From: Laura Gibbons <Laura.Gibbons@arun.gov.uk>
Sent: 03 November 2020 14:25
To: Planning.Responses <Planning.Responses@arun.gov.uk>
Cc: Simon Davis <Simon.Davis@arun.gov.uk>
Subject: Y/99/20/PL

Engineers Comments Regarding Surface Water Drainage

Area of Junction Works drawing 23018/102

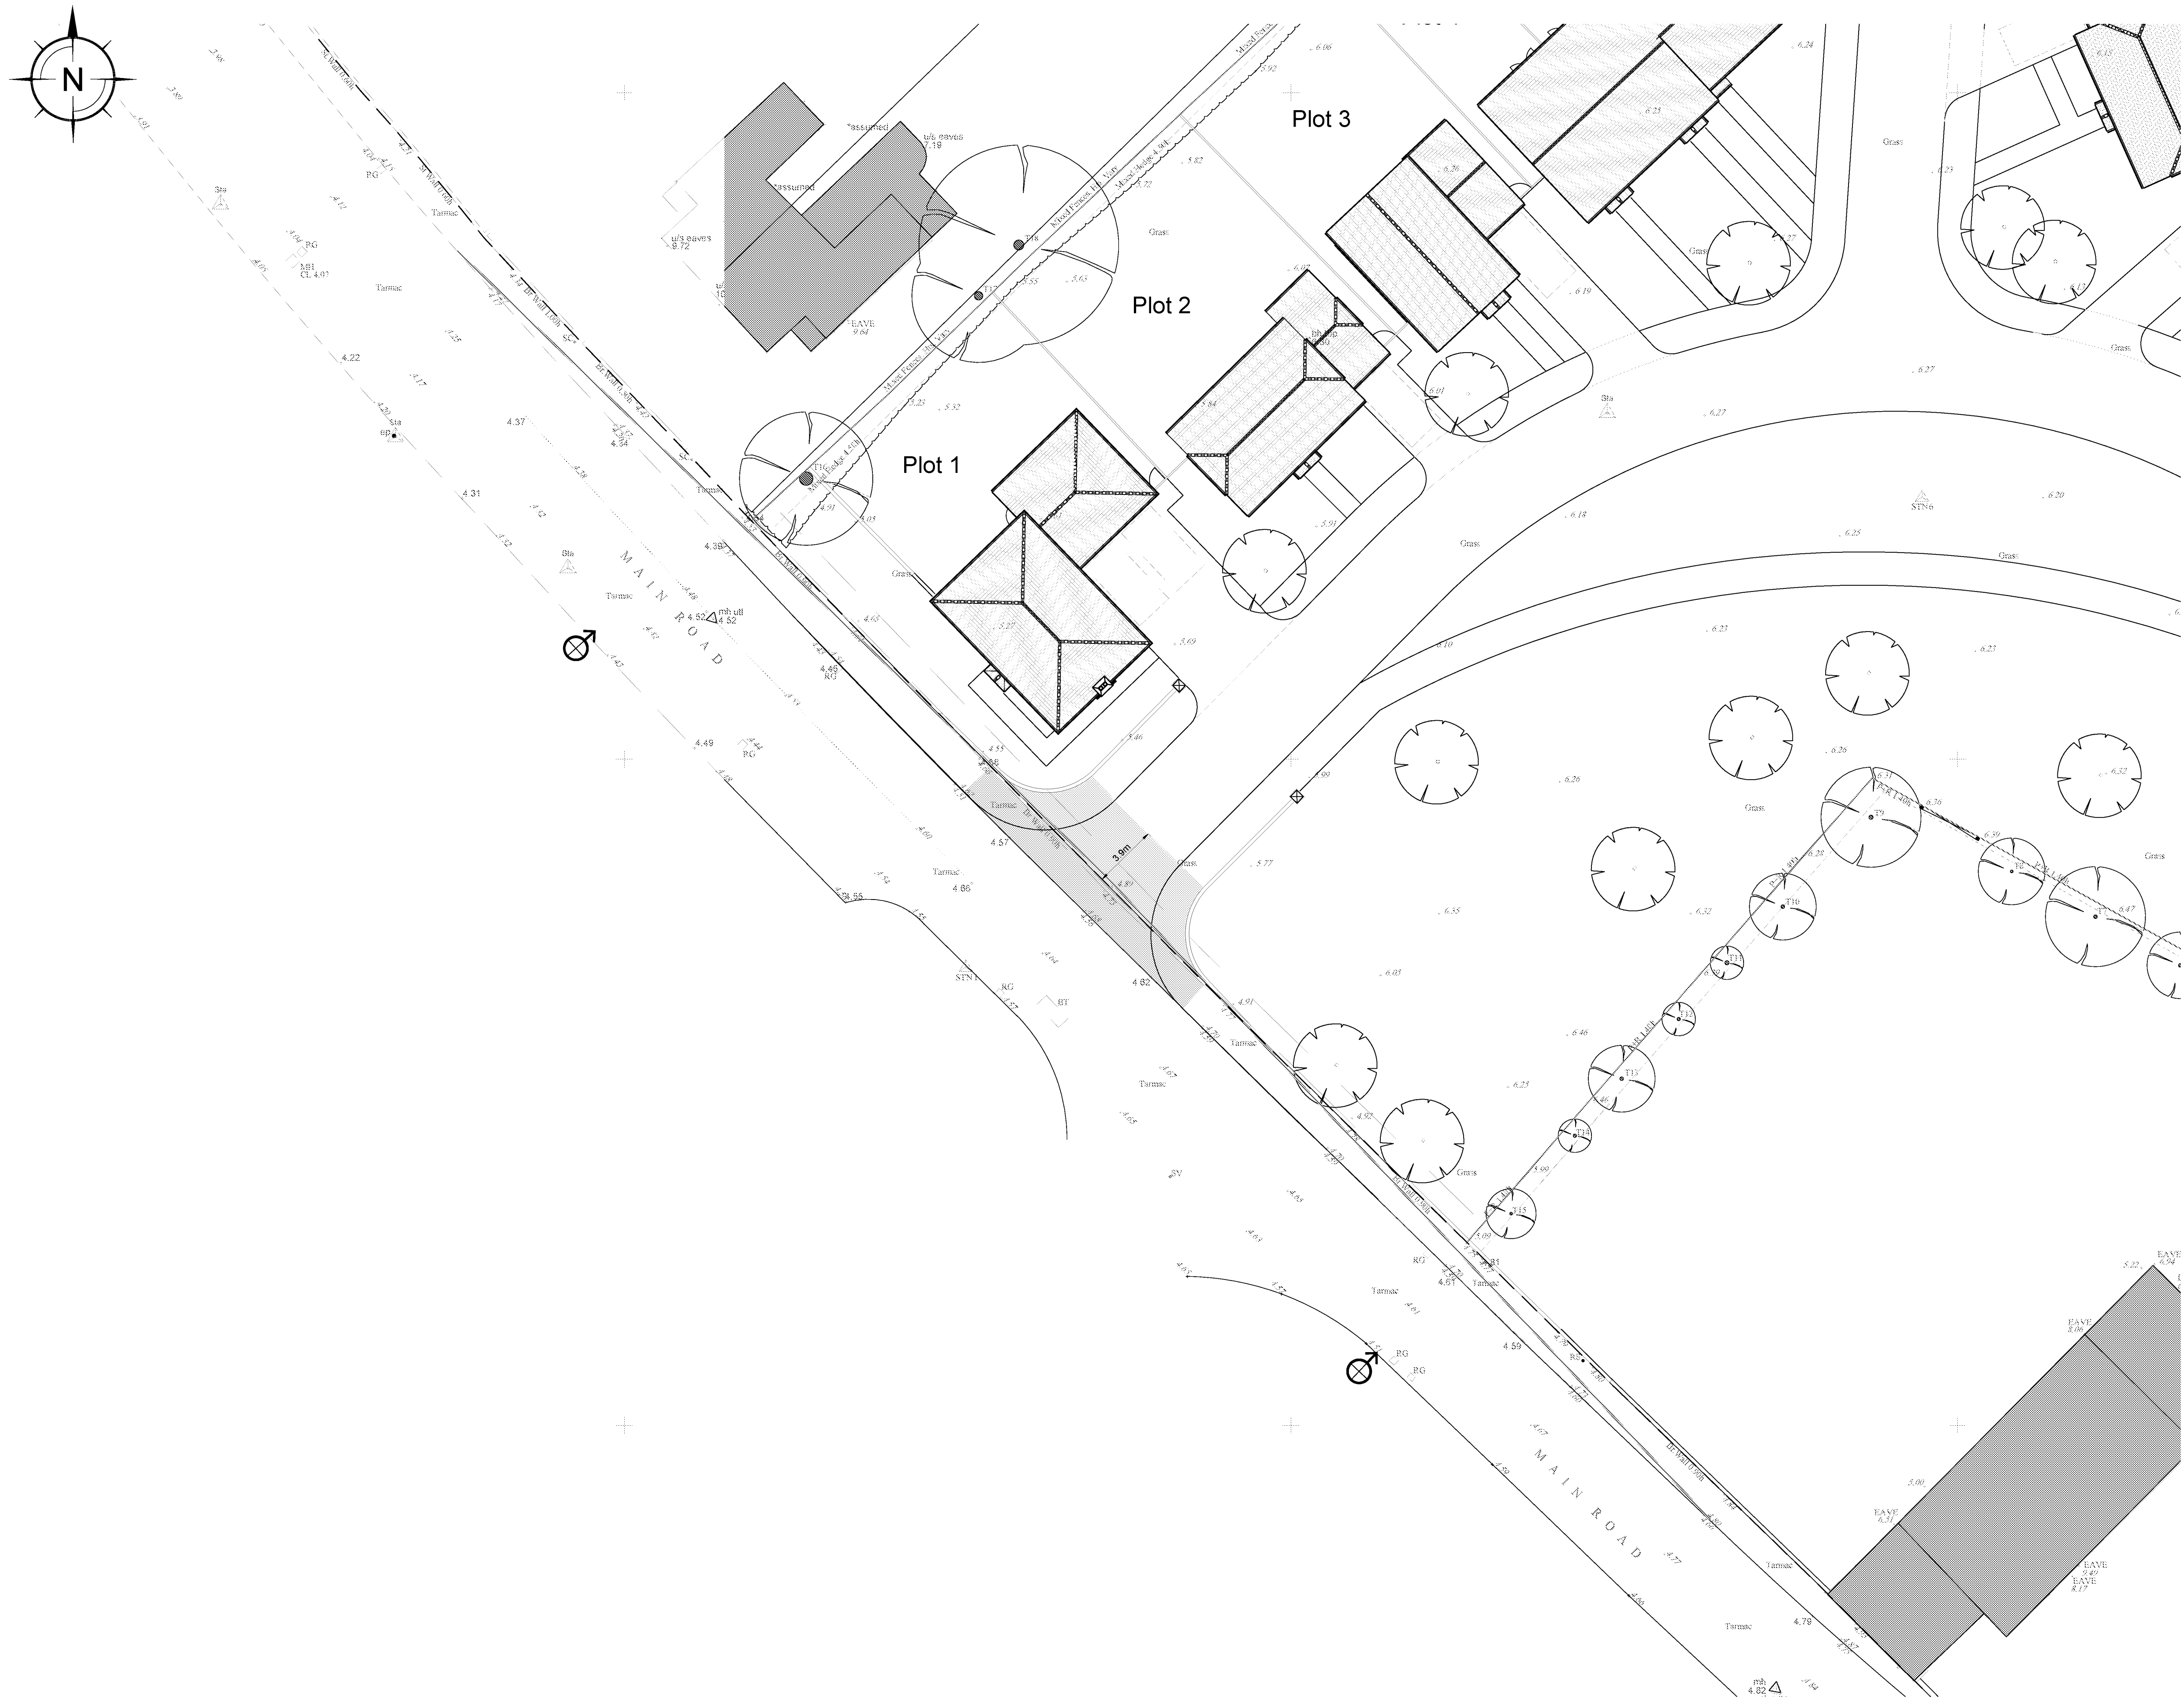
We do have some concerns regarding this application to vary the drainage conditions. The area in the plan referenced within the proposed condition rewording is part of the wider surface water drainage storage area for this site. This area should have a permeable construction. Please can the applicant submit a detail evidencing that this will be the case. This is required to ensure that the access way will not result in highway flooding.

It may be that the access way will have to be reconstructed if the drainage strategy is changed substantially. Please can the applicant acknowledge that if necessary they would make any necessary adjustments to the construction after agreement of the drainage strategy.
